**Our ref:** NO/2019/112169/01-L01  
**Your ref:** 3/2019/0930

**PROPOSED EXTENSION TO FACTORY AND CREATION OF NEW CAR PARK WITH ACCESS.  
CLITHEROE LIGHT ENGINEERING, UNITS A-C, UPBROOKS INDUSTRIAL ESTATE, CLITHEROE, BB7 1PL**

**Environment Agency position**

Scale: 1: 1250 Date

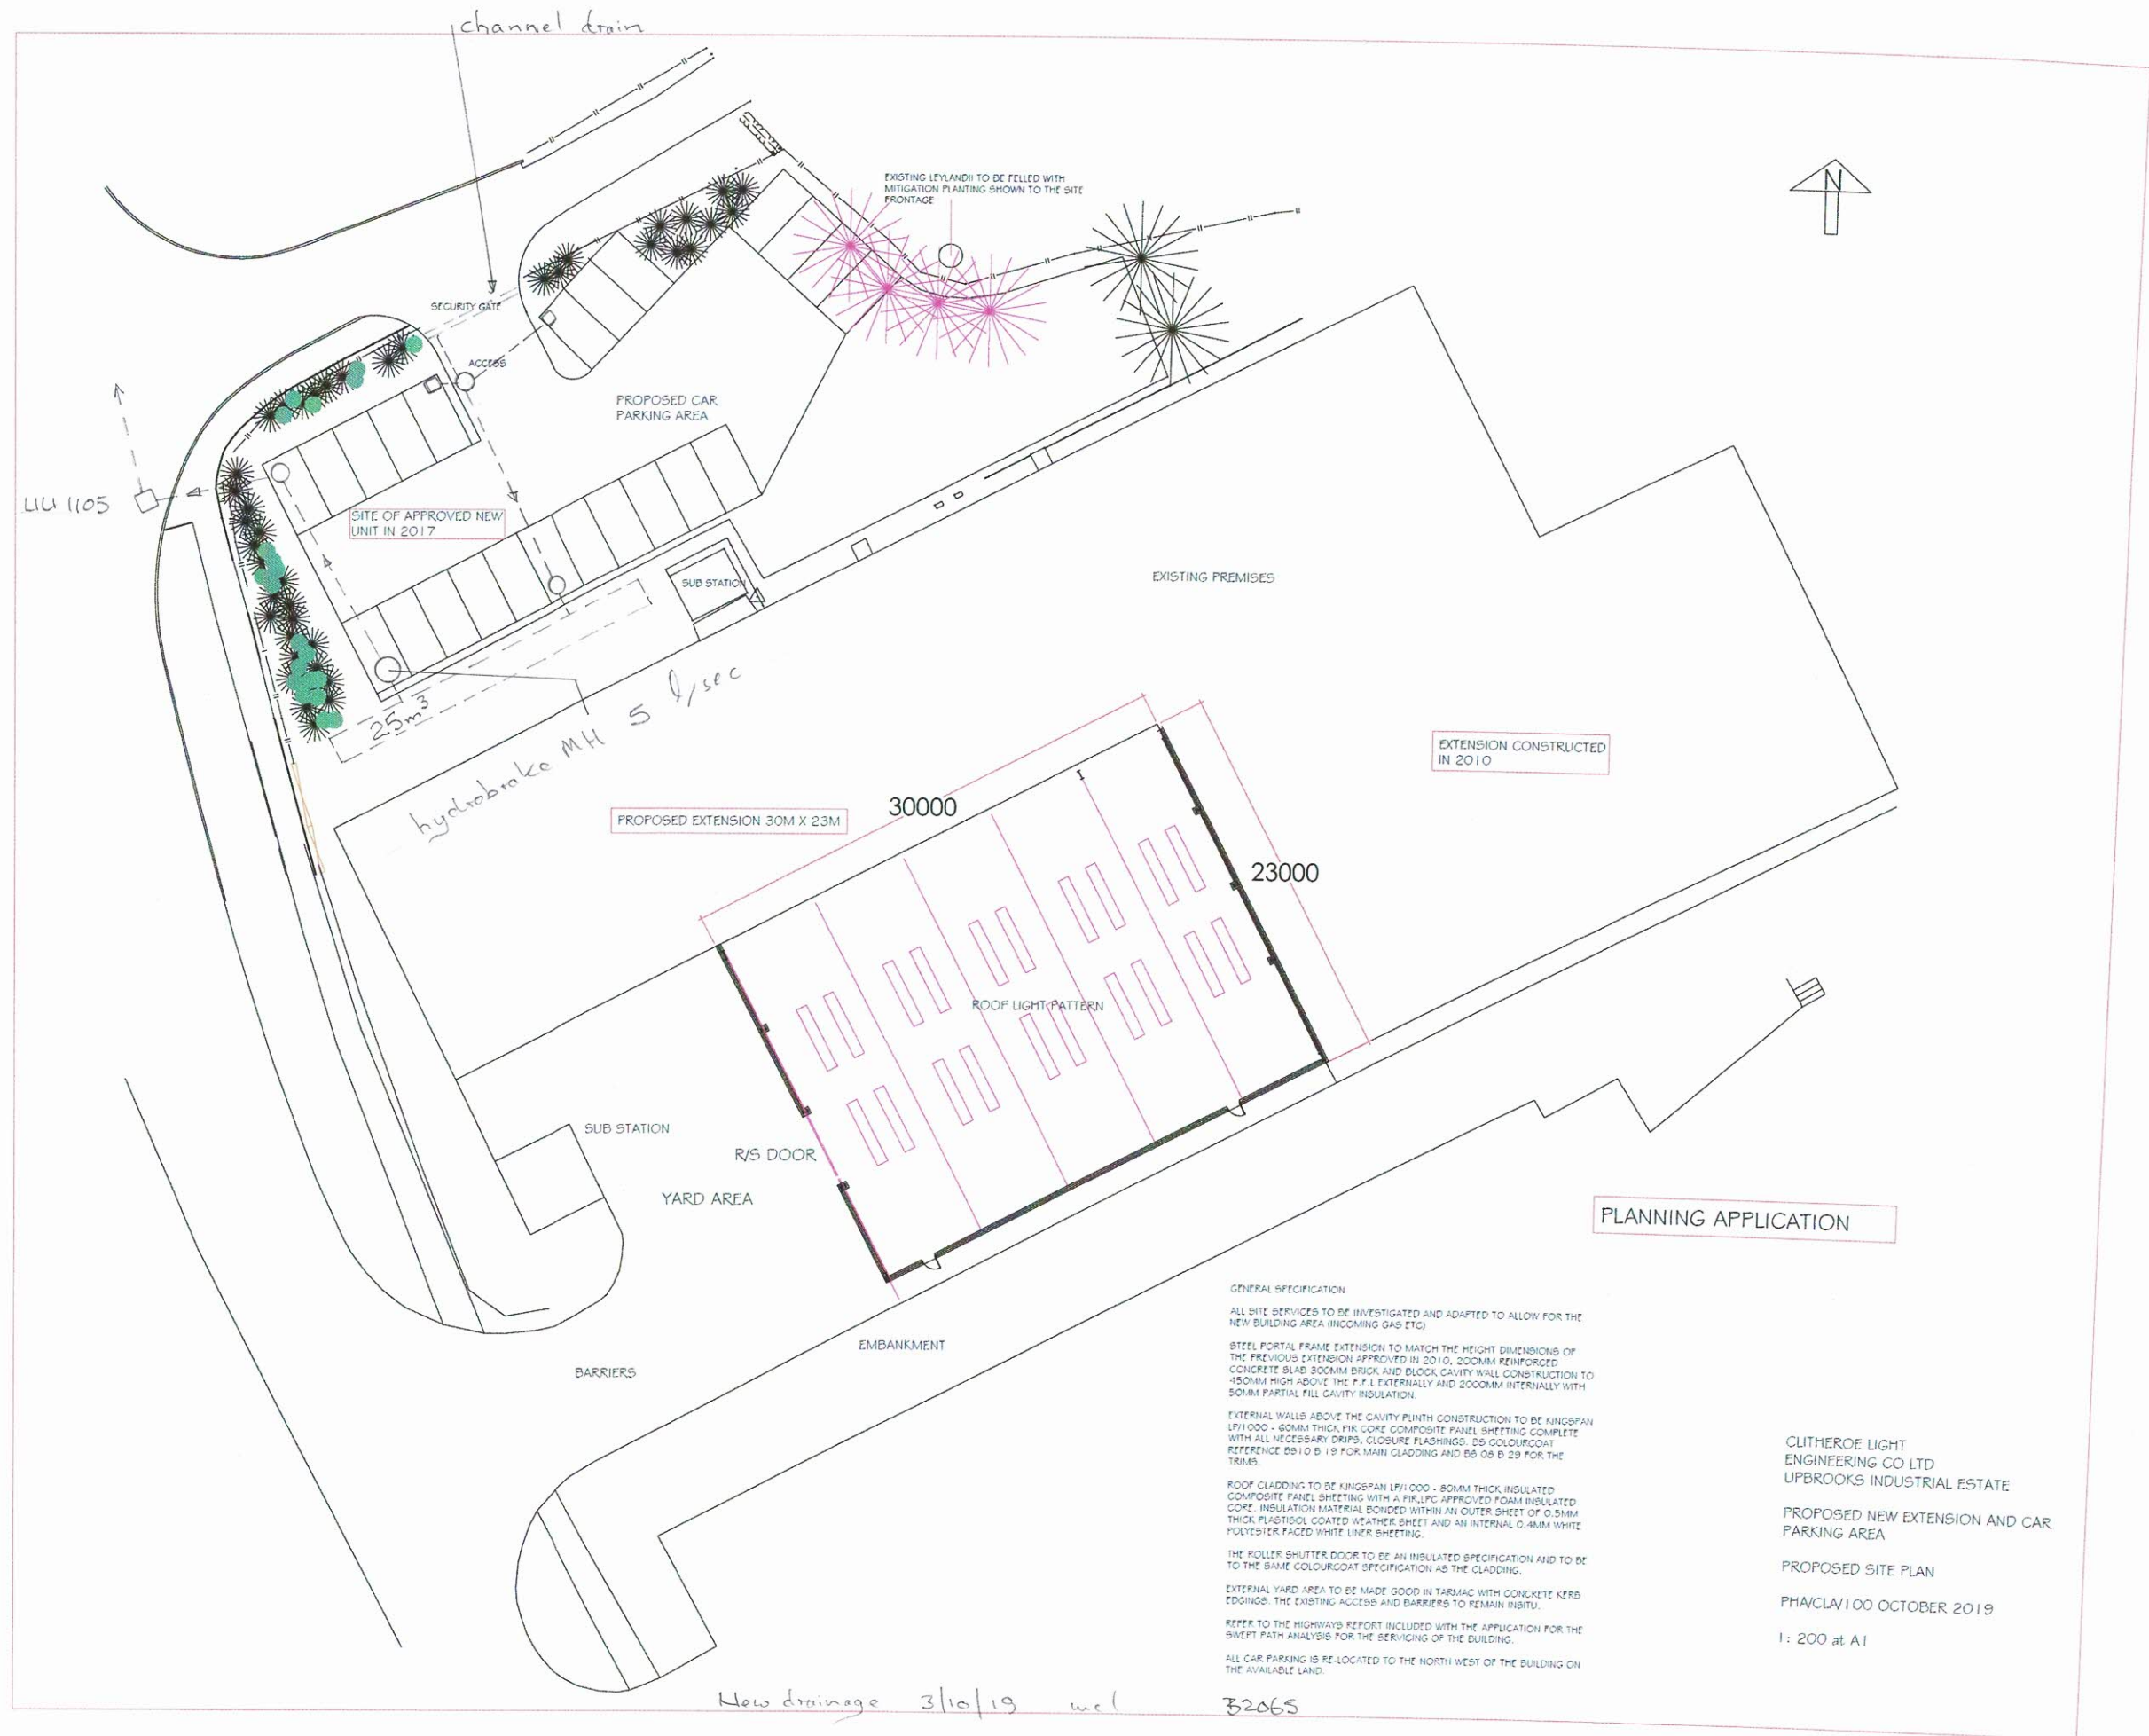
The FRA does not therefore, adequately assess the development's flood risks. In particular, the FRA fails to properly demonstrate that the floodplain will not be infilled by the proposed car park.

- \* a topographic survey to Ordnance Datum.
- \* a proposed car park layout which demonstrates that the proposed ground levels of the car park are the same as existing ground levels, thereby demonstrating that the floodplain will not be infilled and that flood risk to adjacent properties will not be increased.
